From [REDACTED] Chair of the Cliff Villages Solar  
Action Group: Final submission

### **Fosse Green Energy EN10154 Volume 7**

#### **Fosse Green EN10154 9.35 Design Commitments (Clean)**

Figure 3-9

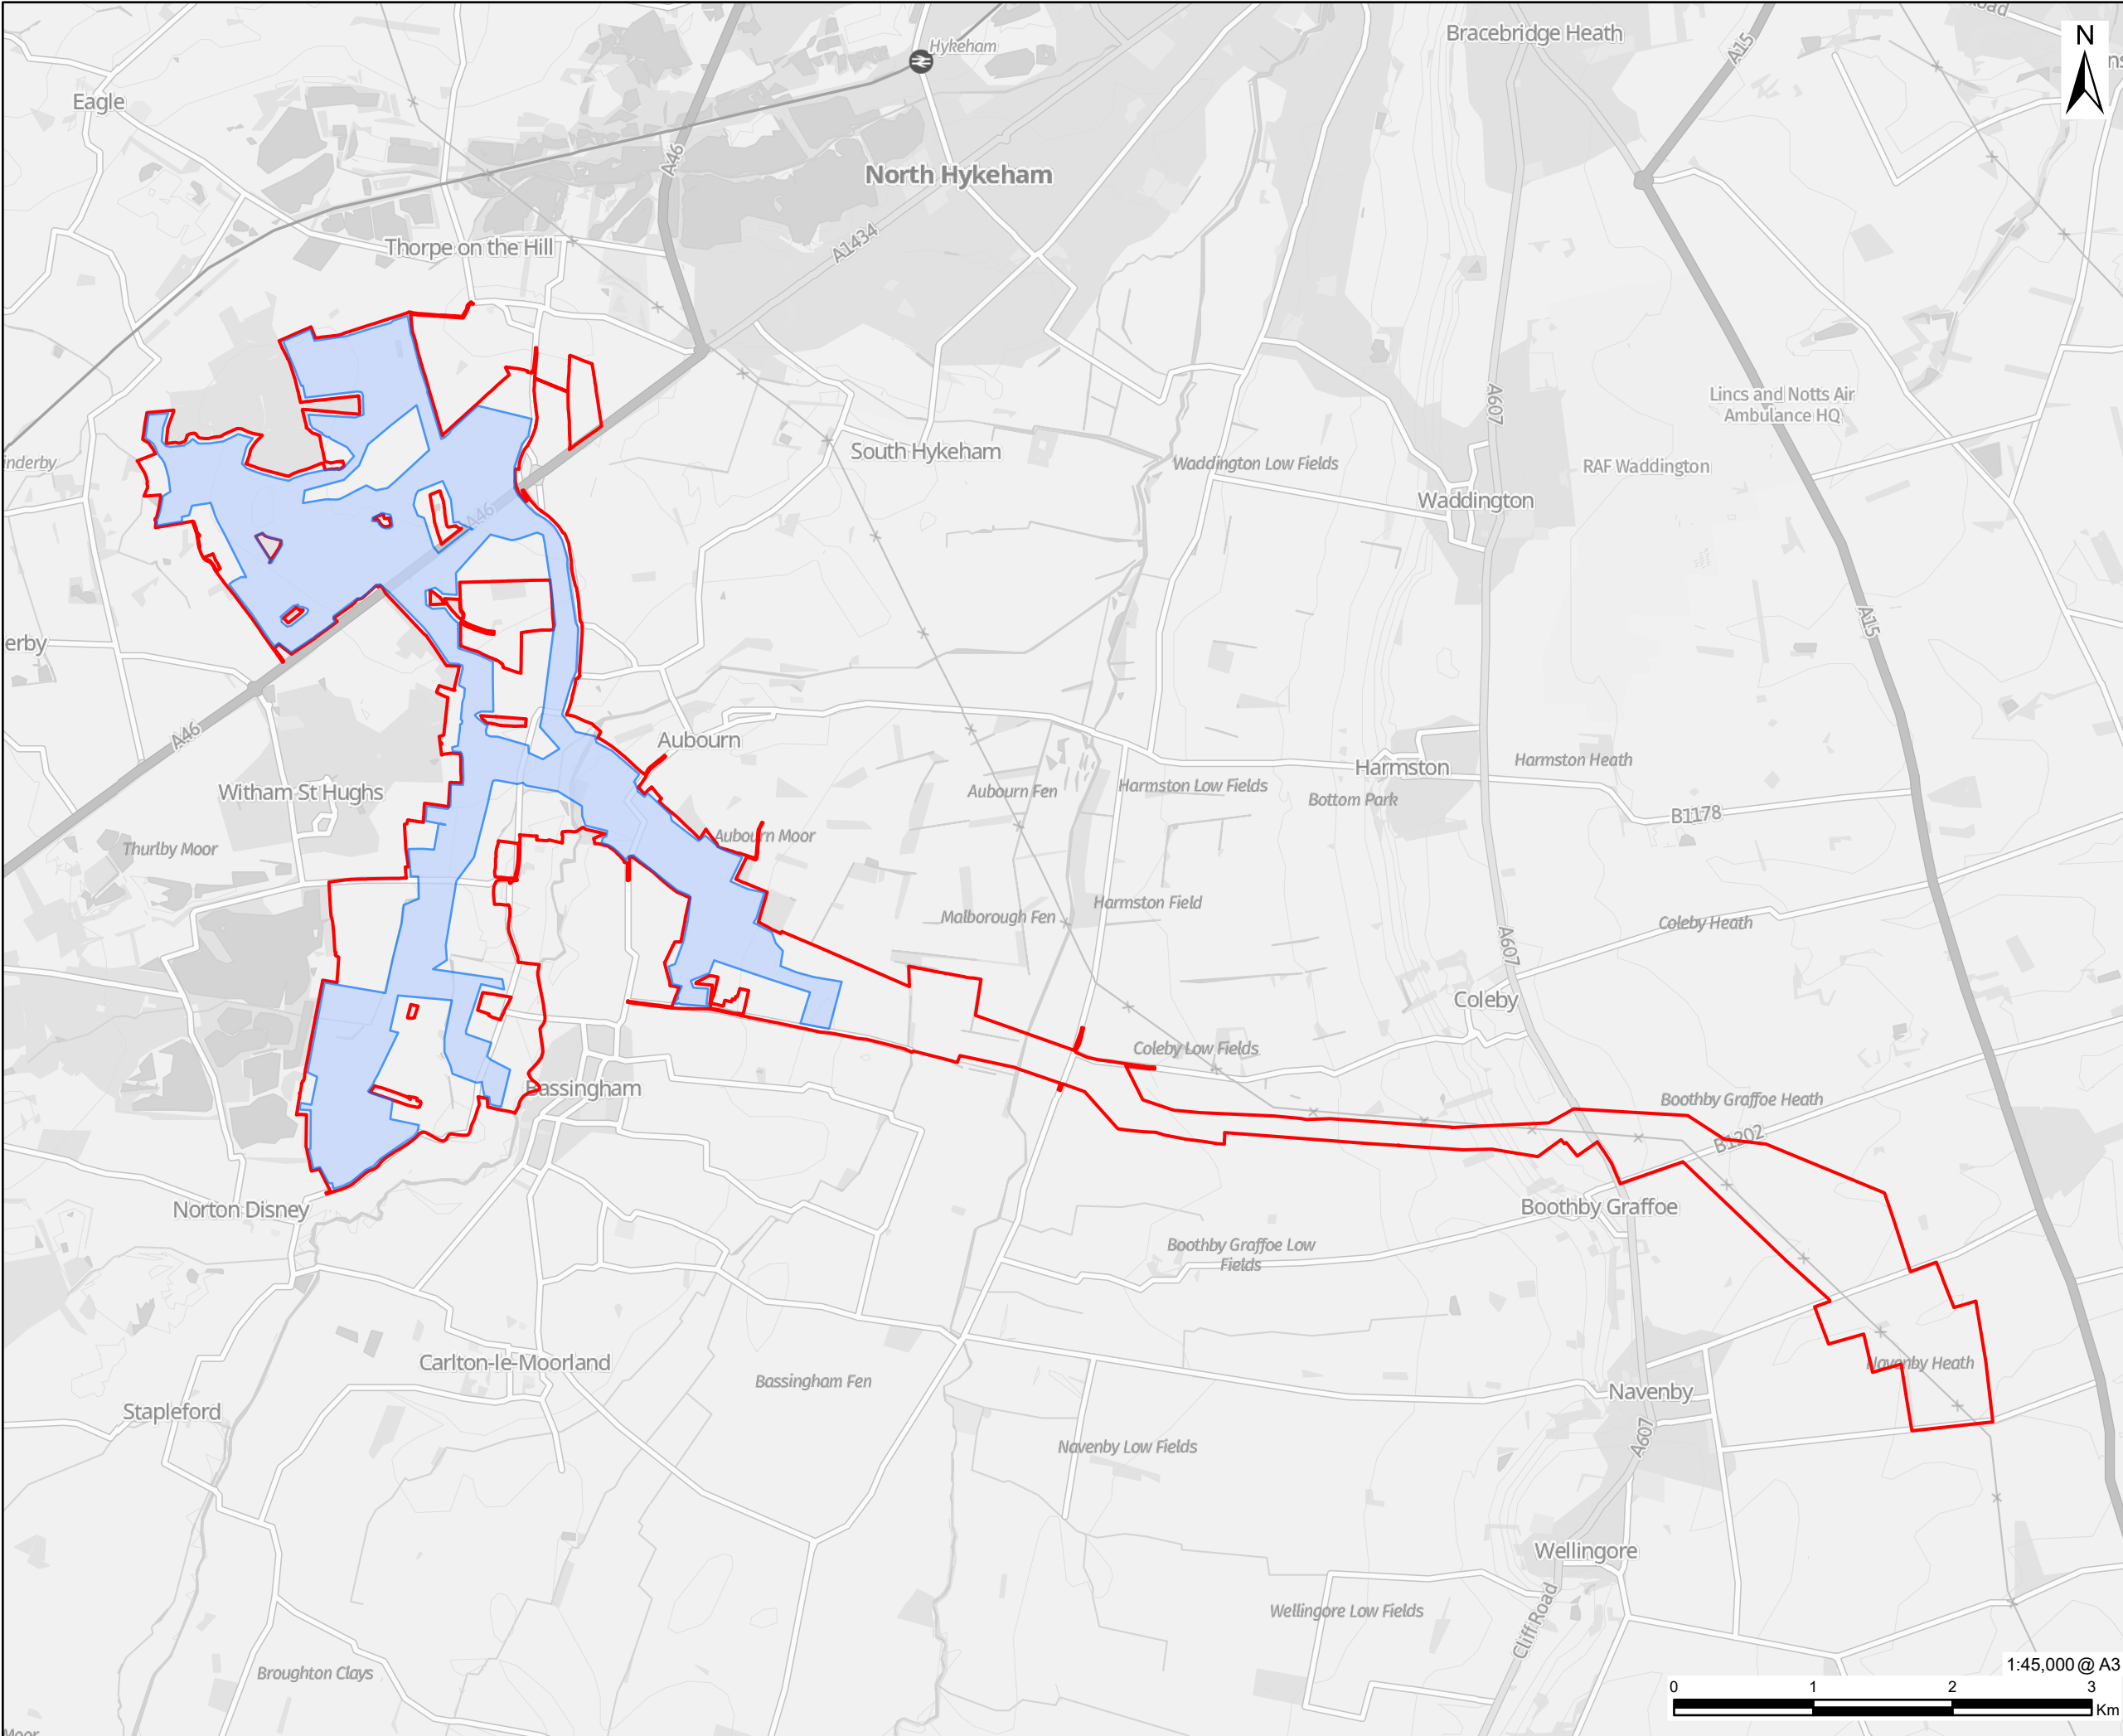
In addition, the cable corridor does seriously damage a wide section of topsoil, much of which is BMV, but details have been omitted here.

FIGURE NUMBER
Figure 10-4A

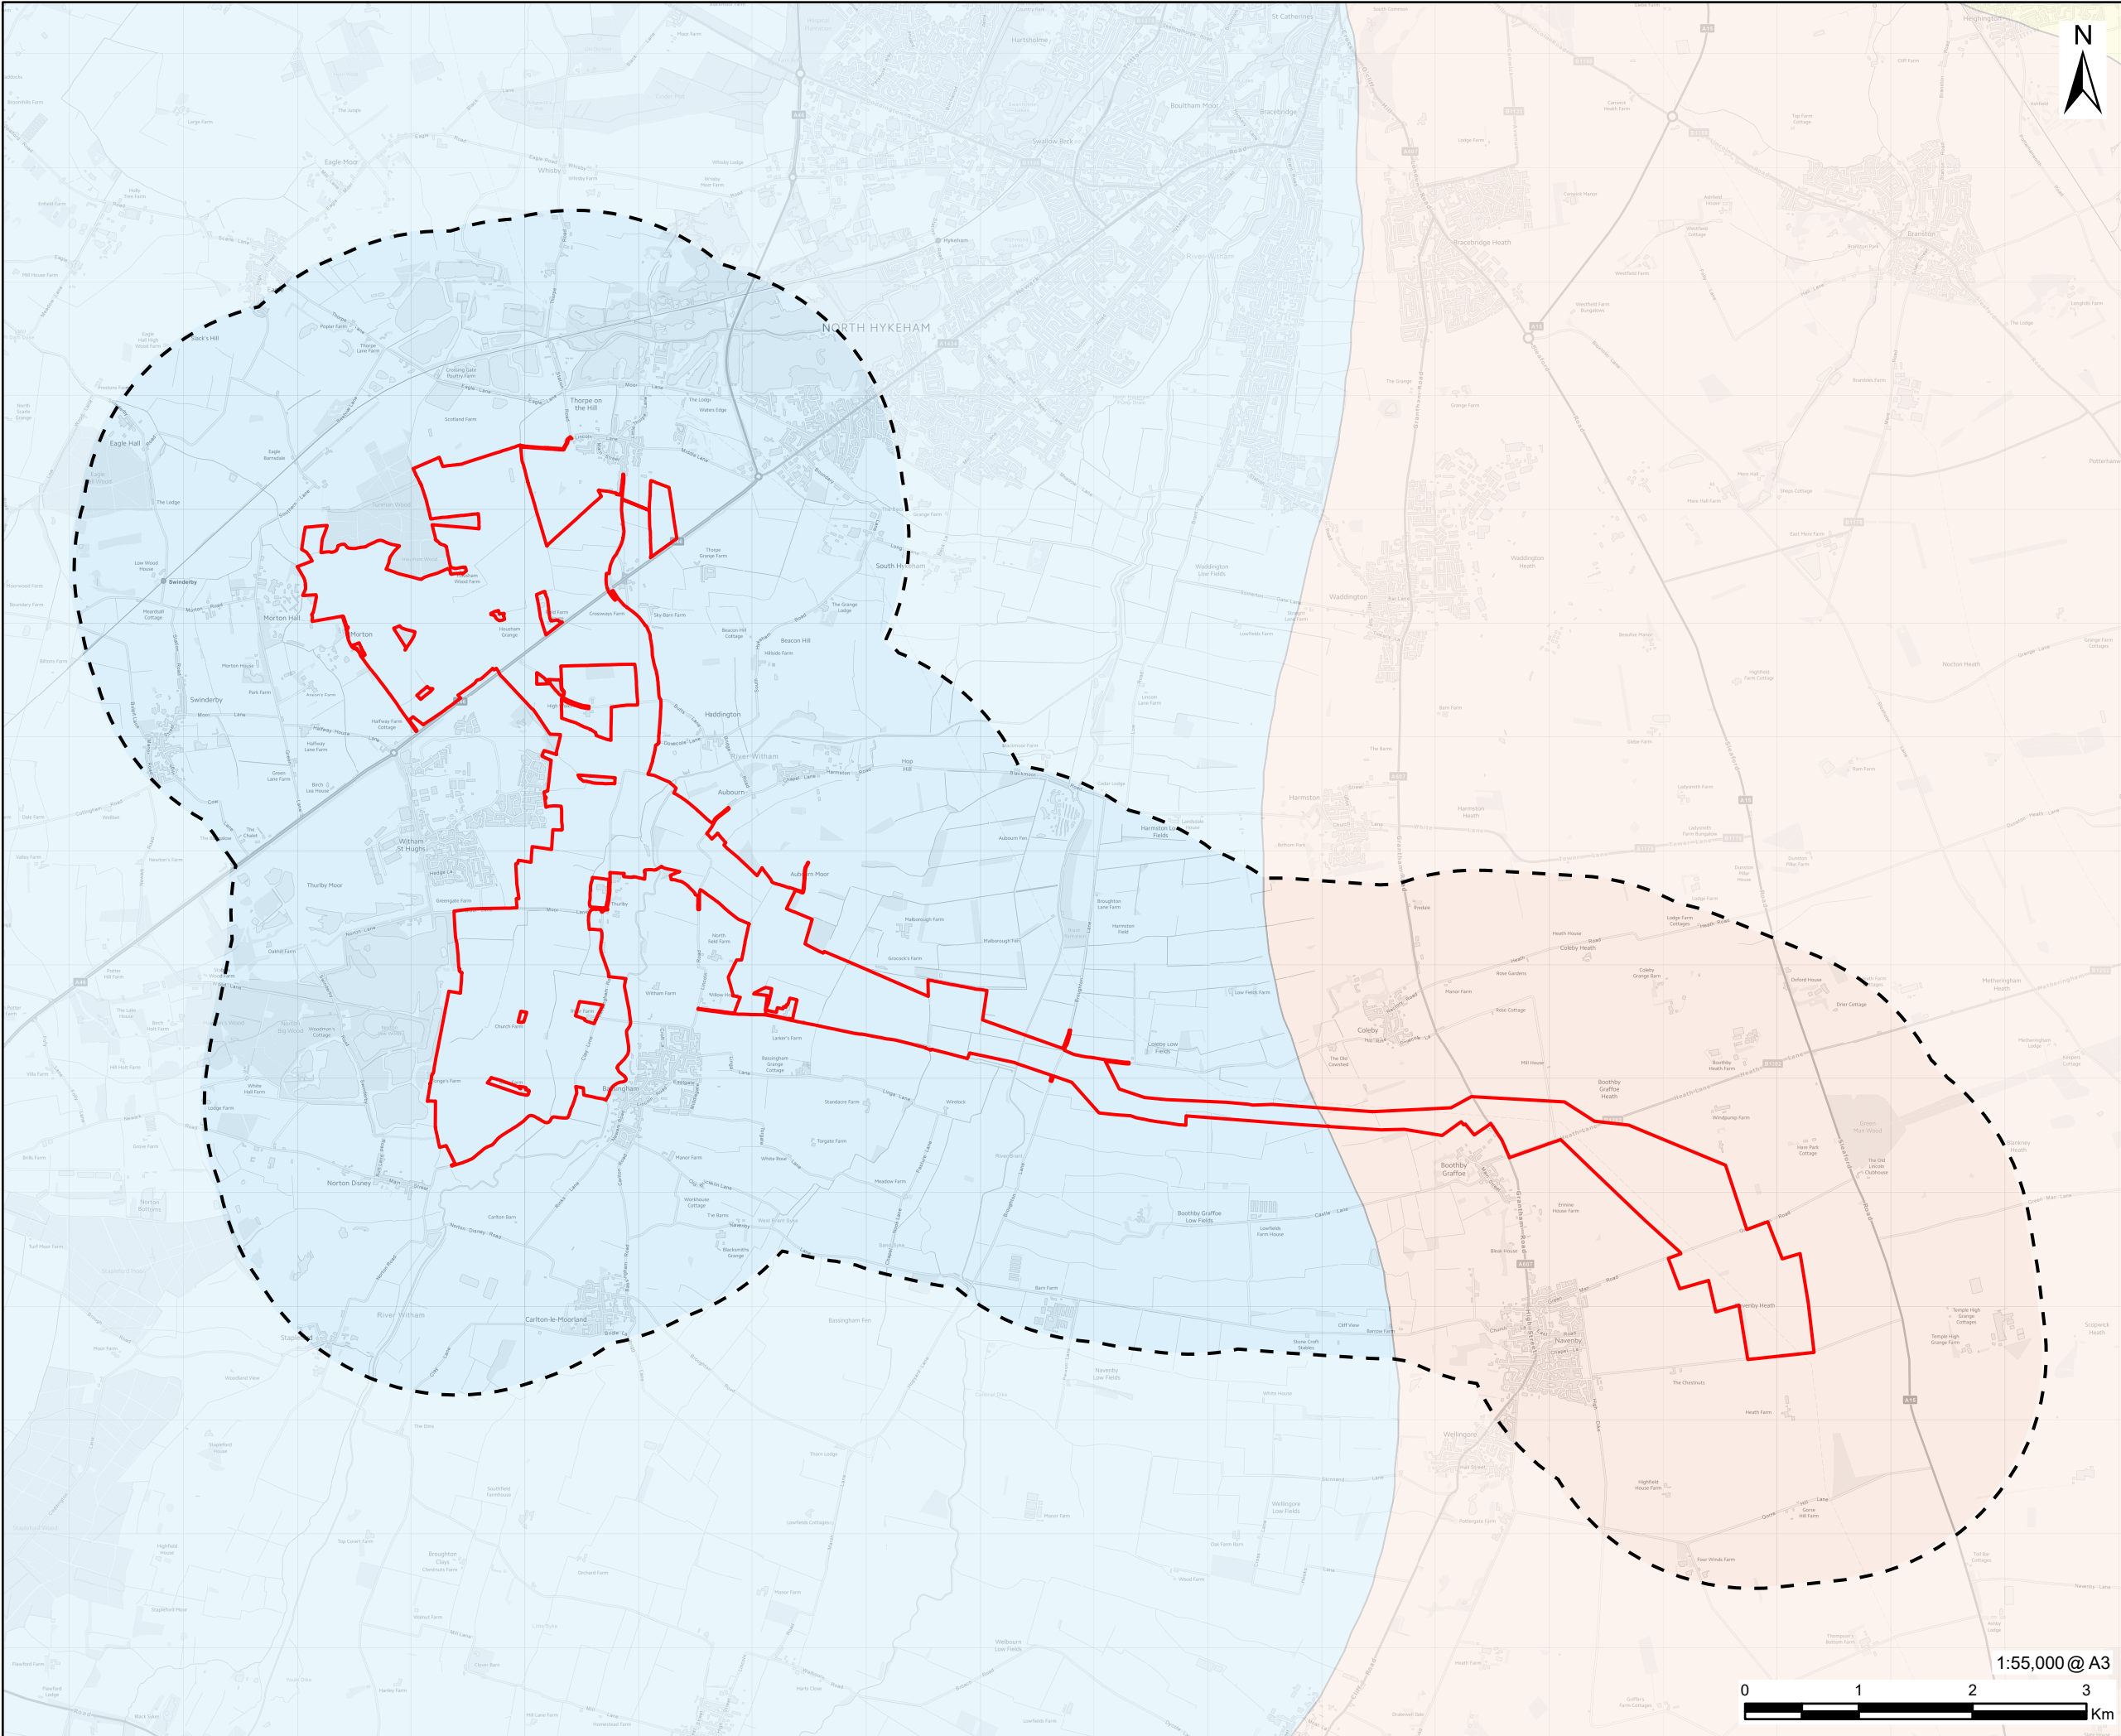
3.6.10 Appendix 10-**C Landscape Character Baseline** of the ES [EN010154/APP/6.3] sets out the key characteristics of the national, regional and local landscape character areas. Land Use 3.6.11

“The Site consists primarily of non BMV agricultural fields of poorer quality.” This is a false characterisation. Referring to grade 3b as “poorer” belies the fact these fields grow excellent grain. 3.6.16 describes the land as 27.8% BMV, with an additional 1.8% not counted and a further 1.8% not accounted for. Including all the land could realistically take the BMV land over 30%, an unacceptable level, even allowing for mitigations.
